Application for a non-material amendment following a grant of planning permission. Town and Country Planning Act 1990

Land adjacent D Brown Building Contractors, Seas End Road

Change of use of 6 holiday lets to one single dwelling.

North West Elevation

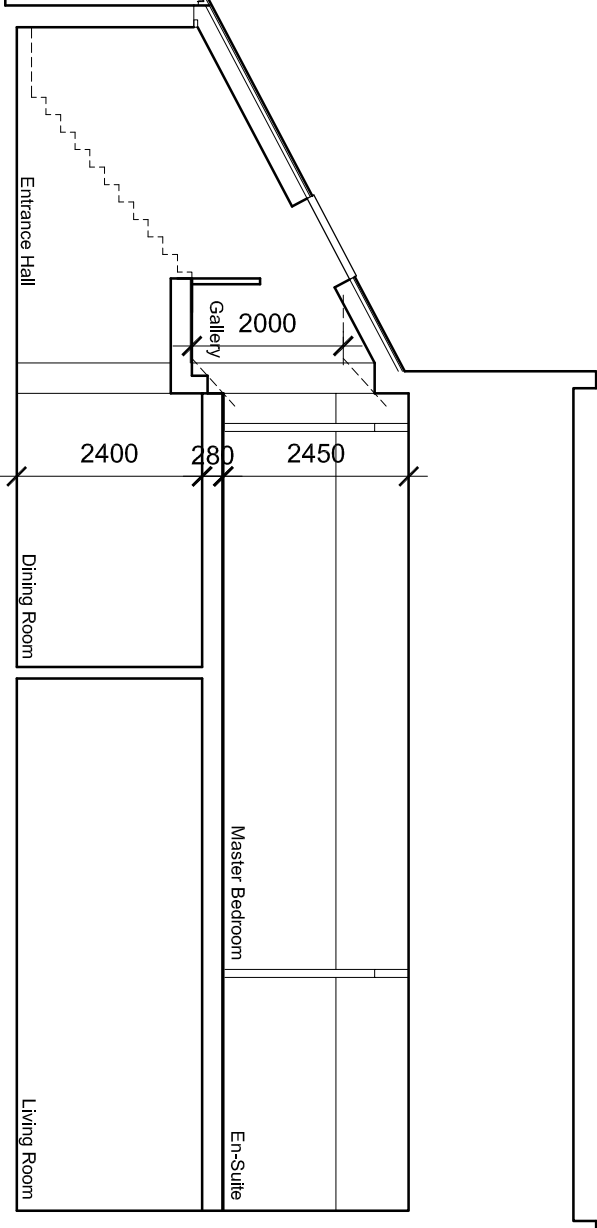
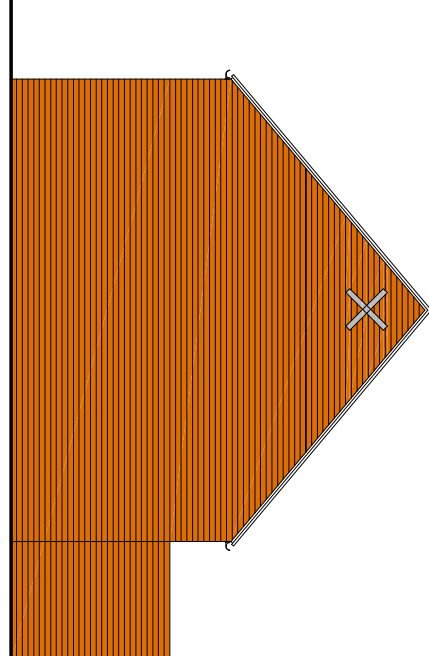
To north-west (rear) elevation, omit 2 no. rooflights and replace with combined rooflight / wall window (Velux type) to facilitate means of fire egress.

Provision of fire egress window to comply with Building Regulations.
